VPI Immingham OCGT

Section 51 Advice – draft Application Documents submitted by VPI Immingham B Limited for The Planning Inspectorate (“the Inspectorate”) review

This advice relates solely to matters raised upon the Inspectorate’s review of the draft application documents submitted in January 2019 by VPI Immingham B Limited (“the Applicant”), and not the merits of the proposal. The advice given is without prejudice to the acceptance or otherwise of the eventual application.

Drawing Title
OTHER DEVELOPMENTS CONSIDERED FOR CUMULATIVE IMPACTS FIGURE 17.1

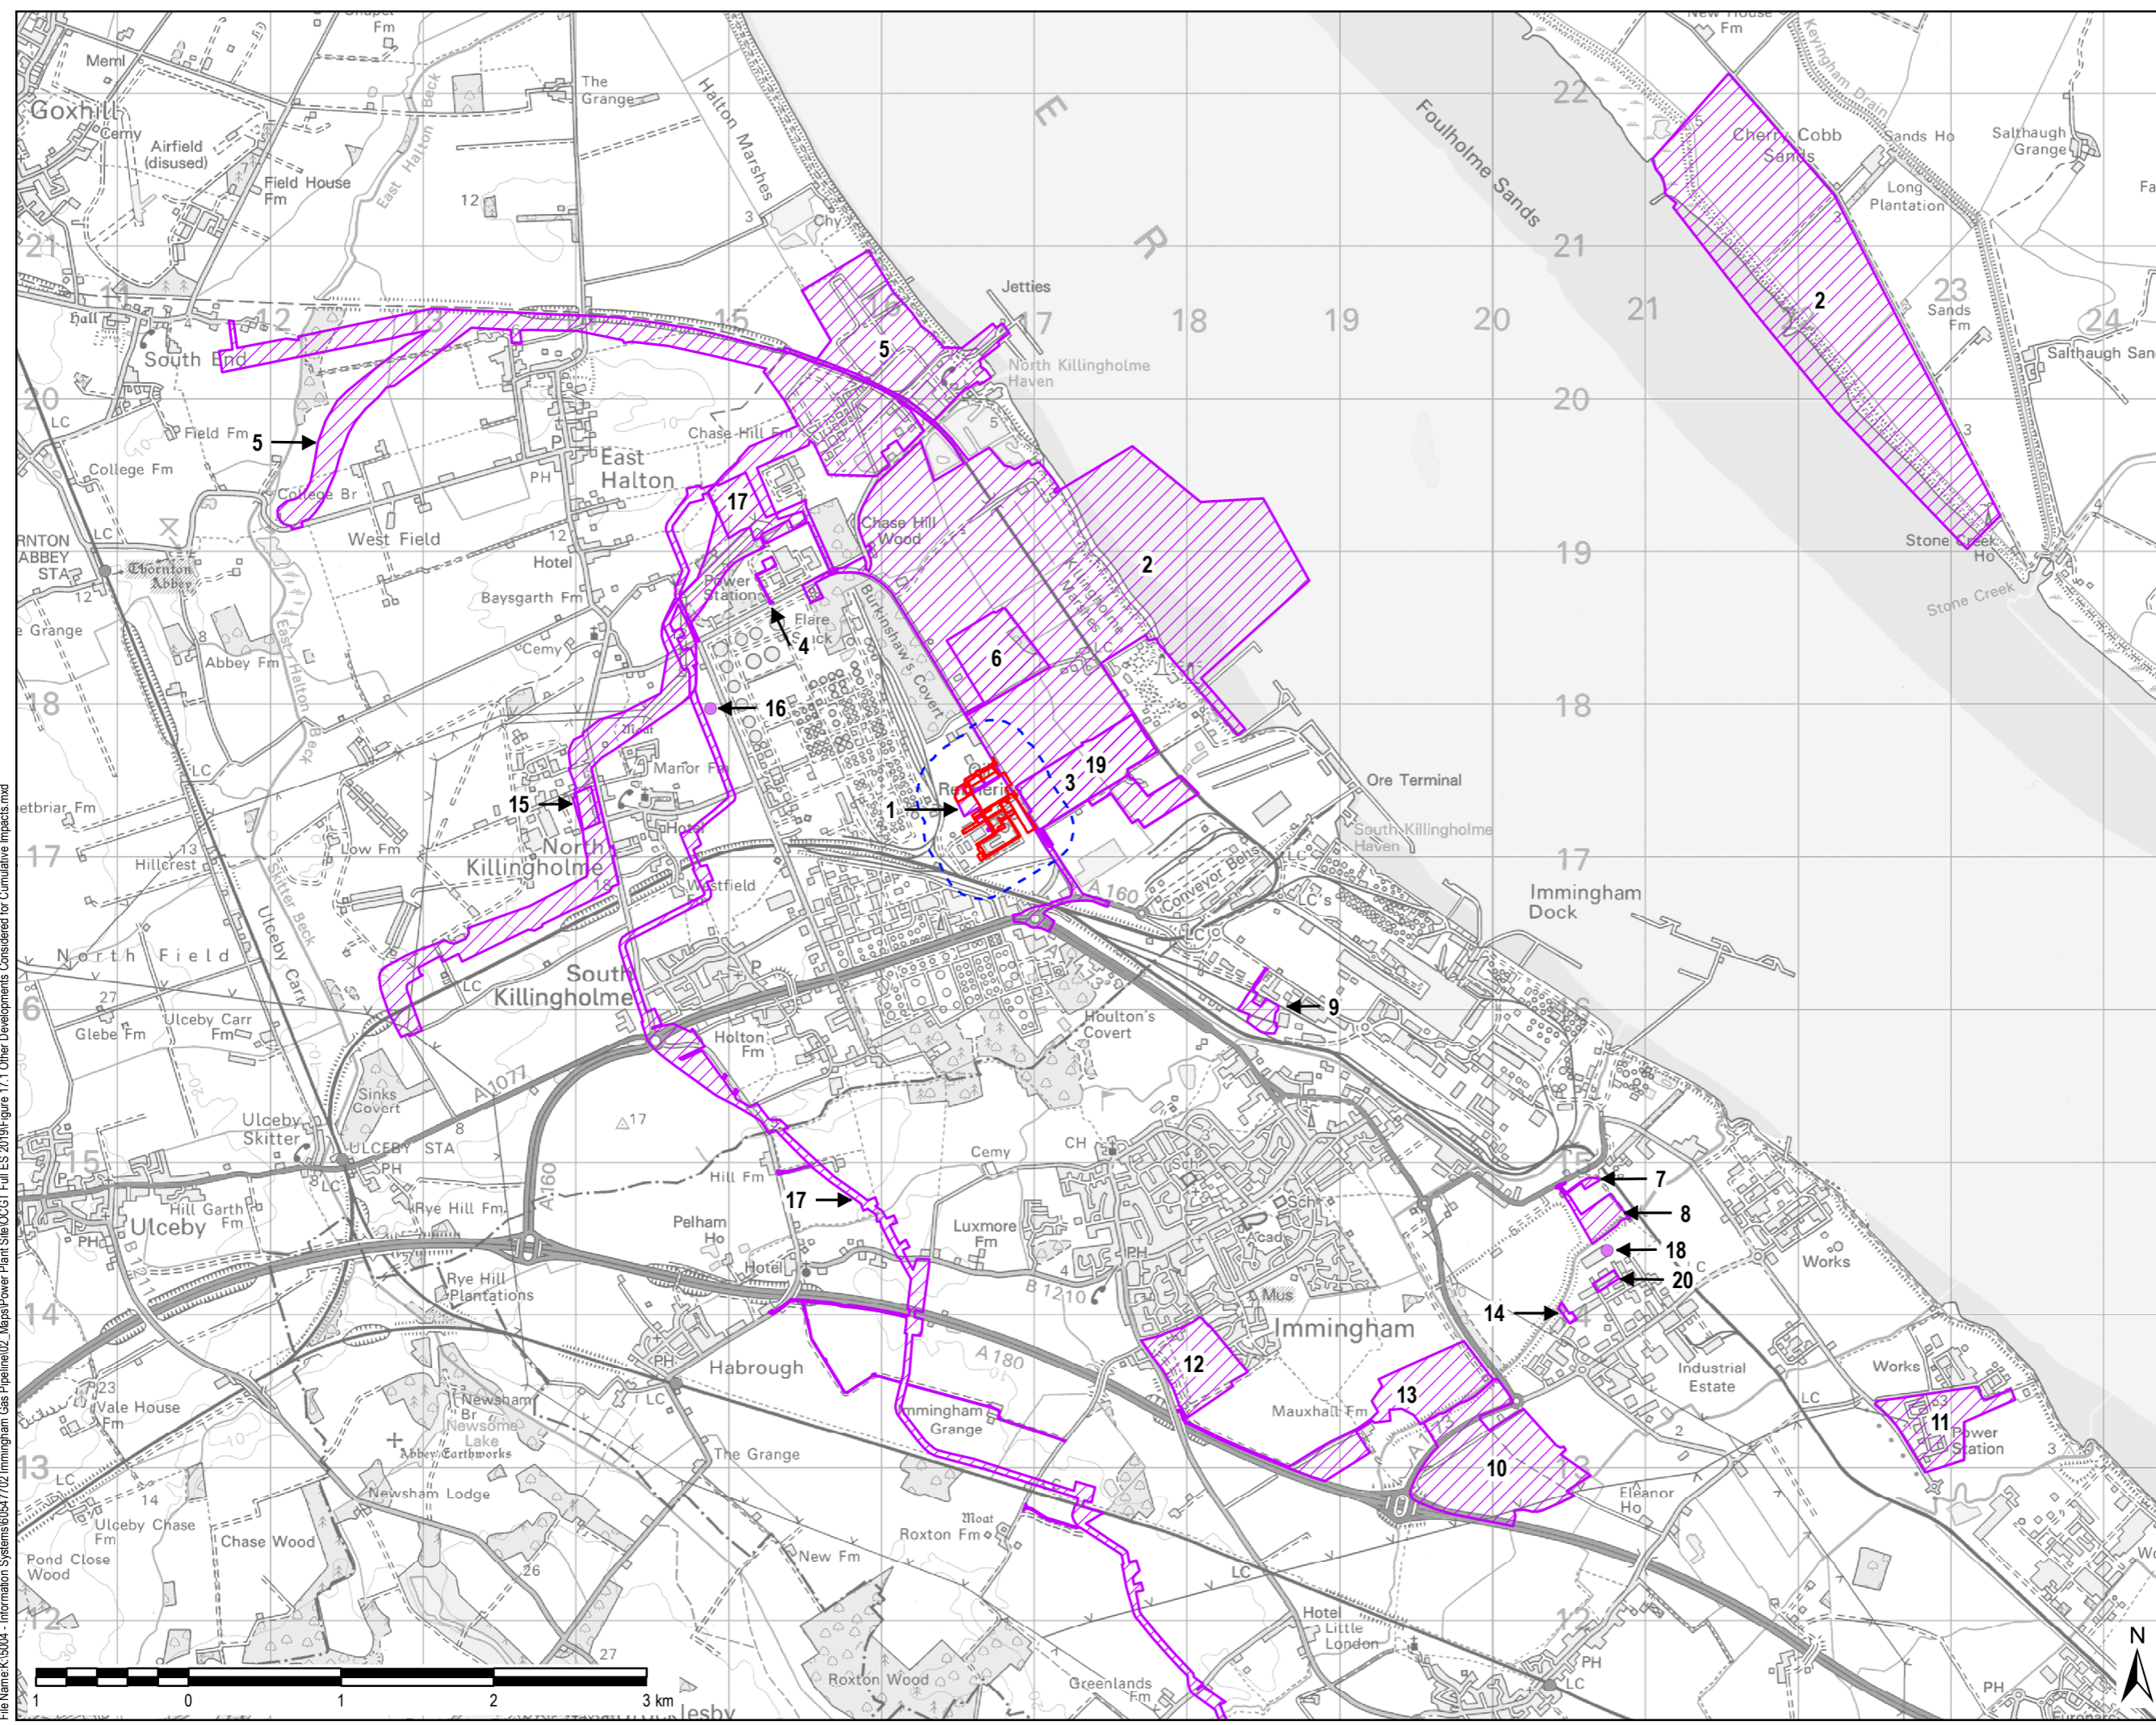
Draft Habitats Regulations Assessment Screening (dHRA)			
Q No.	Paragraph	Extract from dHRA	Question/comment
8.	Table 9B.3: Summary of Projects Considered in Cumulative Effects Assessment in the PEI Report		<p>In-Combination Effects with other Plans or Projects</p> <p>The Applicant should consider including a figure that illustrates the locations of the other projects/ proposals considered for the in-combination/ cumulative assessment.</p>
